Necton Parish Council Boreas Representation 21 January 2020

Our ref : NORB-004

Plate 7 Refined Onshore Project Substation Zone

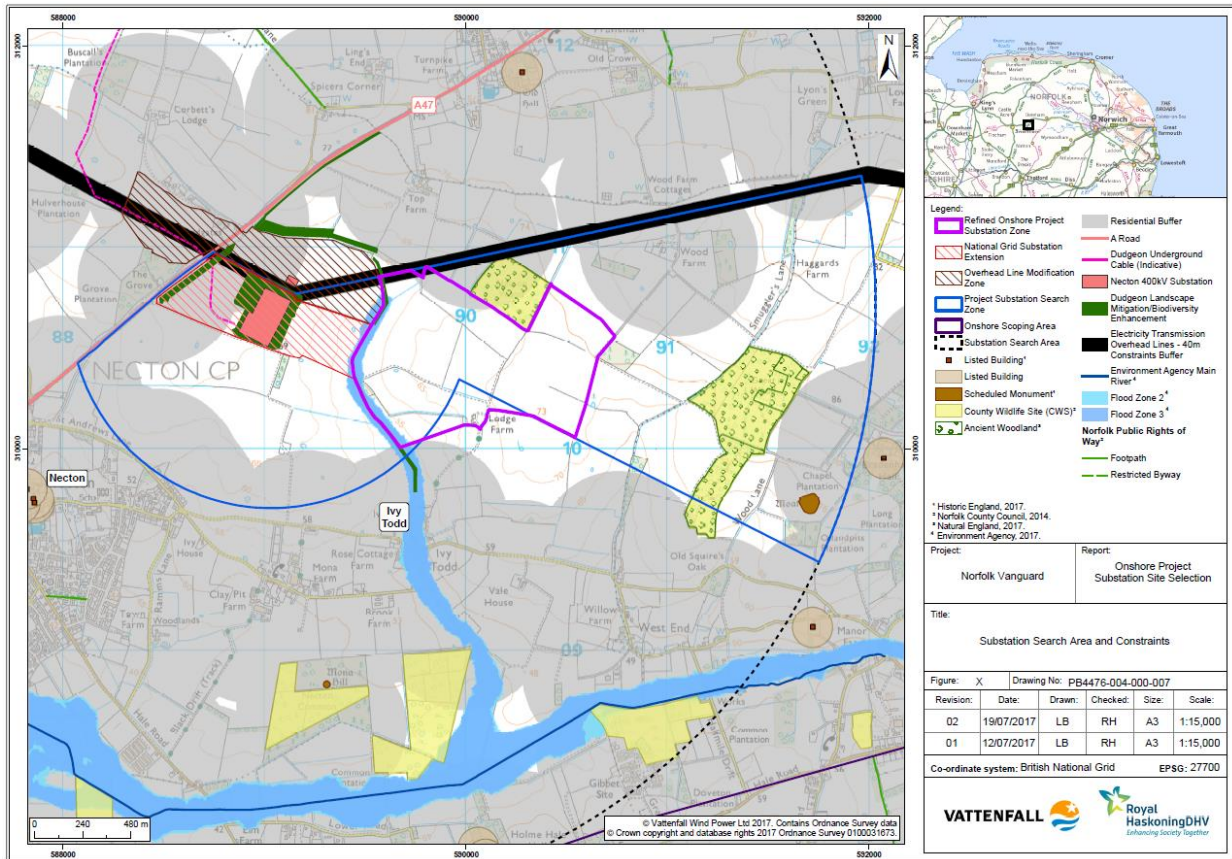
Since the converter halls will be placed on relatively high ground, Vattenfall have stated in their DCO that screening will not be effective. However, we believe that screening could be effective for Ivy Todd and Necton if placed here (place screening on model) and you can see that the raising of the trees (green area) on the bank (white area) is an important requirement, especially in the first ten years as the trees are quite small when first planted. Ideally, the trees would be further from the converter halls but the compound would have to be bigger to accommodate this benefit.

For your orientation for the accompanied site visit on Thursday, this is the Top Farm position we proposed for the converter halls (place flag and re-position converter halls). As you can see, it's less obtrusive. Vattenfall have stated this site would be more expensive to use because of the additional movement of earth required. We would like that earth not to be wasted, but to be repositioned as the screening bank.

**APPENDIX 2: SLIDES SHOWING ONSHORE PROJECT SUBSTATION
INFRASTRUCTURE (AGENDA ITEM 4 (b) I)**

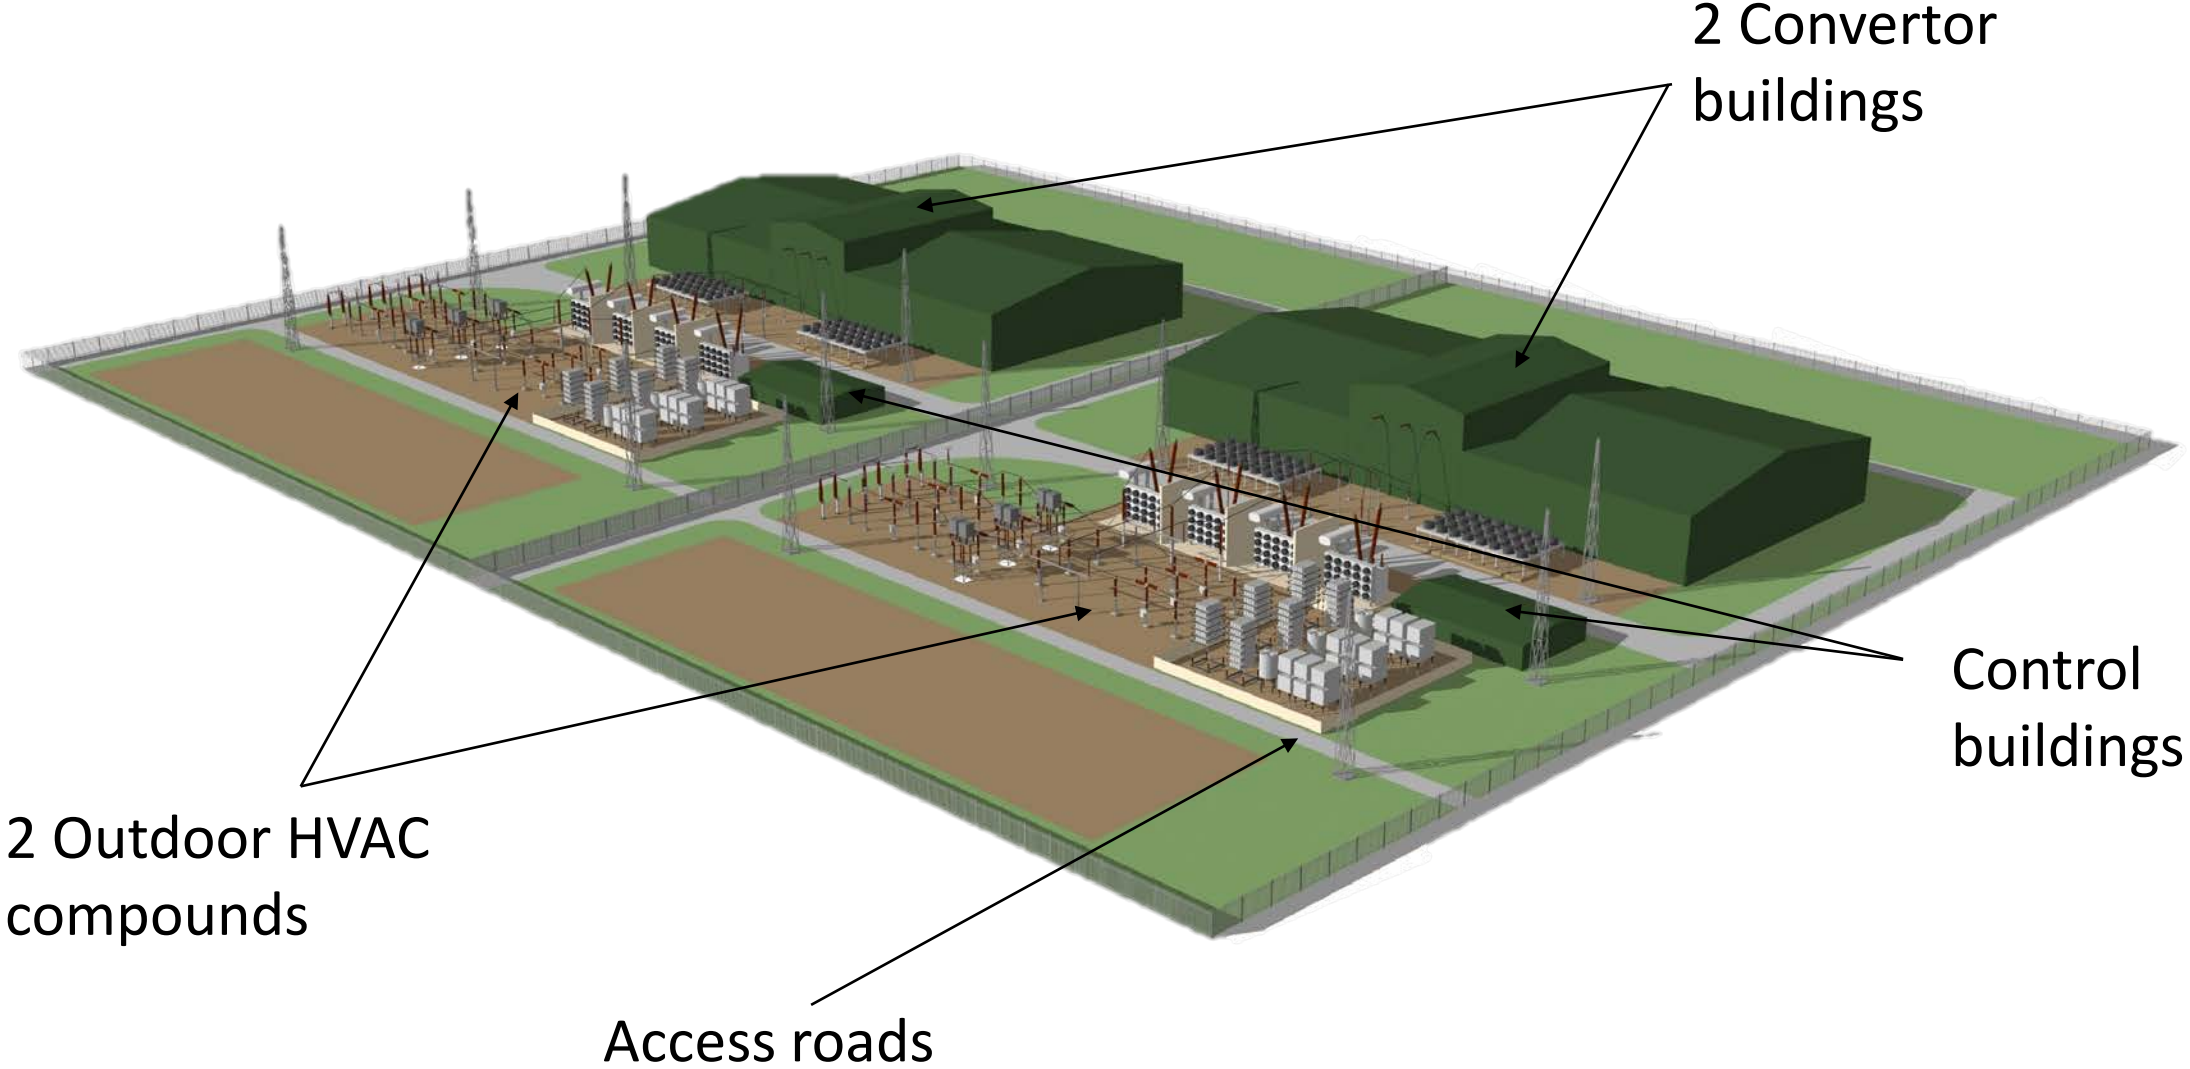
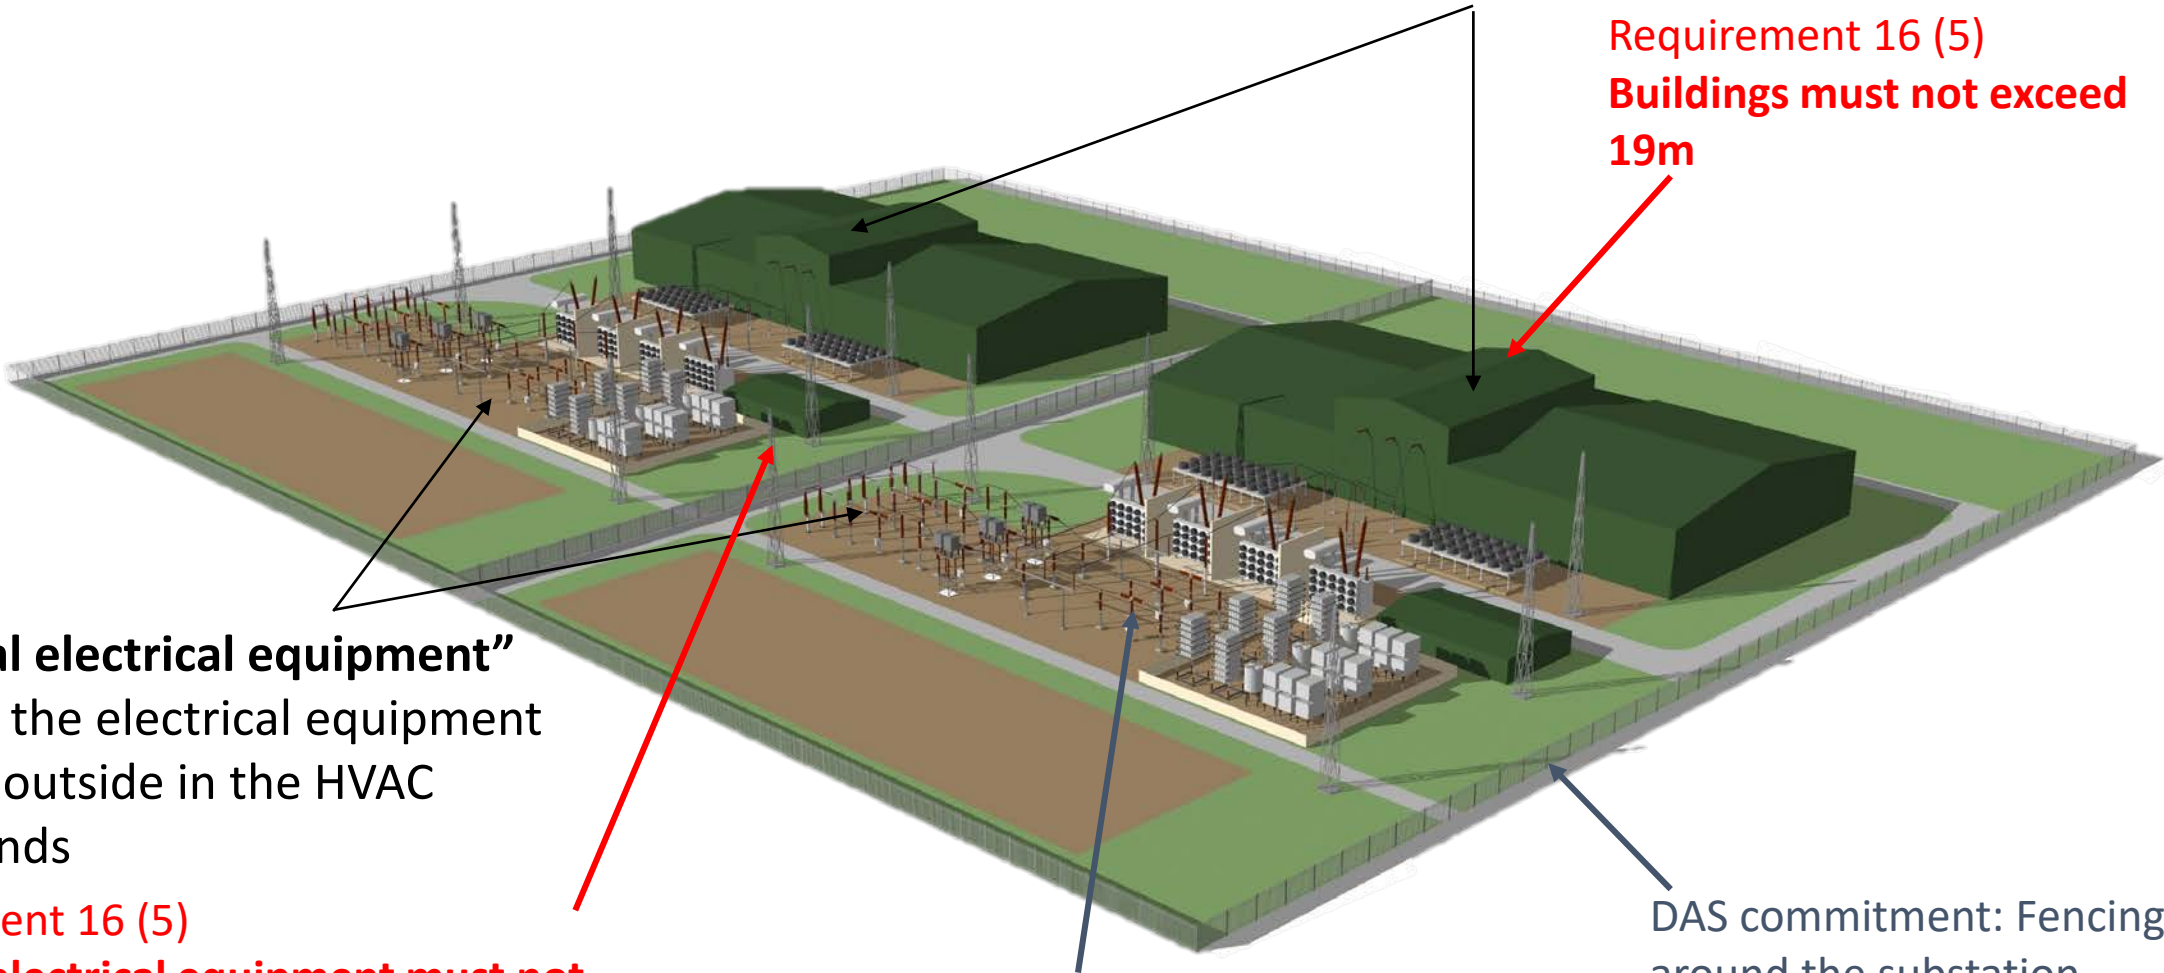
We used the Ordinance Survey contour data for the area (show it) and put together this three-dimensional model in front of you. In it you will see the A47, the stream, Necton Wood and the current Dudgeon AC buildings with their associated National Grid infrastructure. This is a model of the Boreas and Vanguard substations and the DCO places it here (place on model) behind Necton Wood and also beside the Dudgeon substation here. However, Ivy Todd and Necton will not be screened by the wood because they lie in the opposite direction (place flags on model). The converter halls are DC rather than the AC of the Dudgeon substations which is why they look so big in comparison. The scale is correct. You will see the size of the Dudgeon substation on the accompanied site inspection. This A3 picture produced by Julian Pearson that you've already seen shows the size of the Boreas converter halls with a London double-decker bus inserted to give scale.

Each building 19m high, 110m long and 40m deep

47 buses long, 5 buses high
And still there is some shed parts showing
